Northorpe Lane Mirfield Planning Application 2021/62/91914/E

I wish to make an objection to the above planning application.

Drawing **Proposed Site Layout**

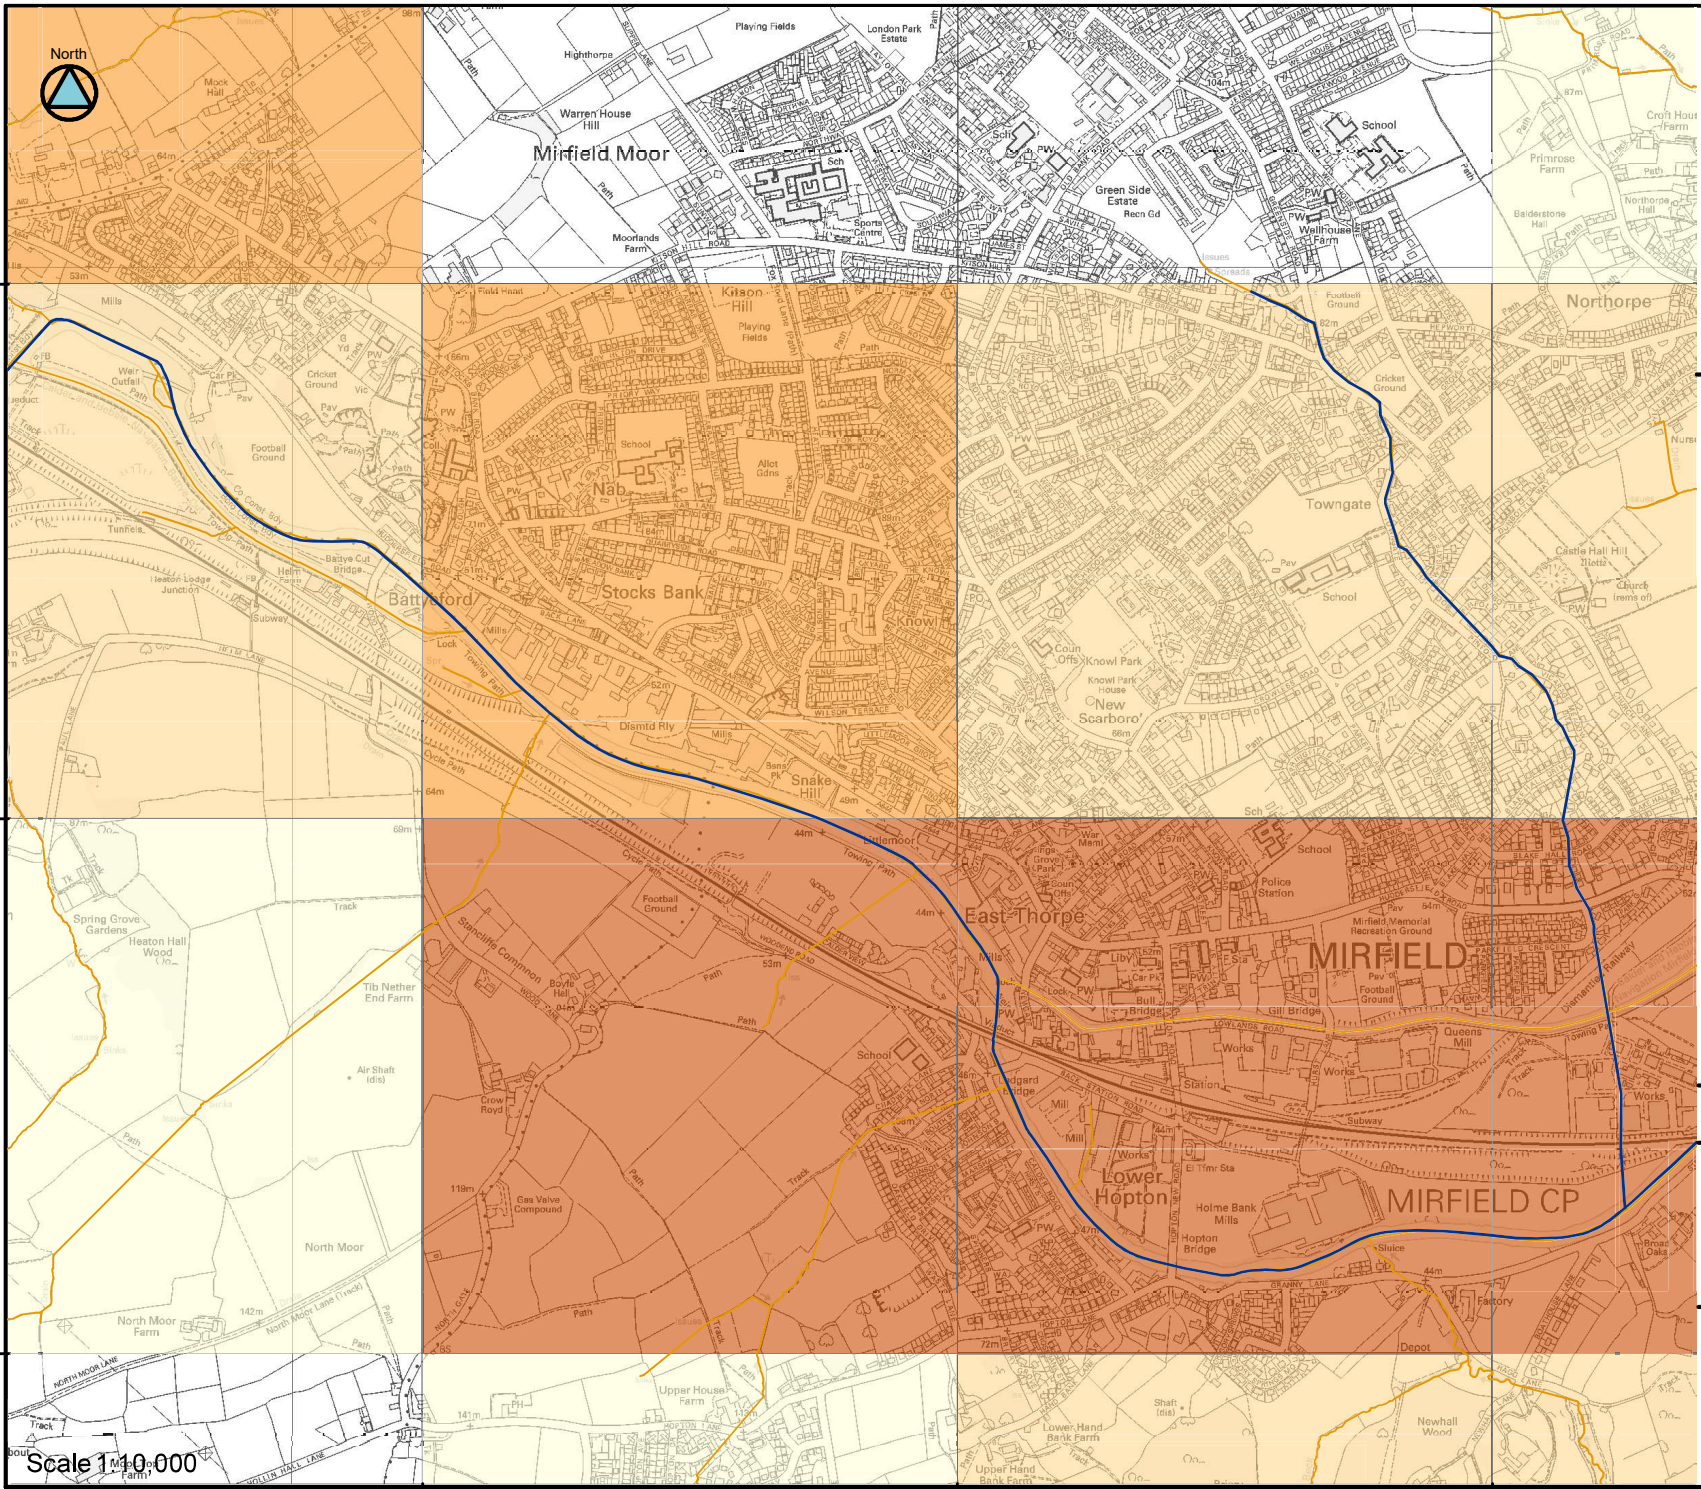
In the very limited time available for review it is difficult to see that much if any of the issues raised against the previous layout have been addressed. From a side by side look at the layouts it is clear the housing density and compact nature of the application remains, despite the reduction to 43 properties. This is exacerbated by properties that were on the edge of the railway banking having been moved further into the site.

The pumping station has moved South East, requiring a greater pumping effort to get the waste up to Northorpe Lane.

The POS has been removed completely.

Site access remains an issue. This requires the creation of a layby by taking a strip of land from the green verge opposite the proposed site entrance. This verge is wholly owned by Northorpe Hall.
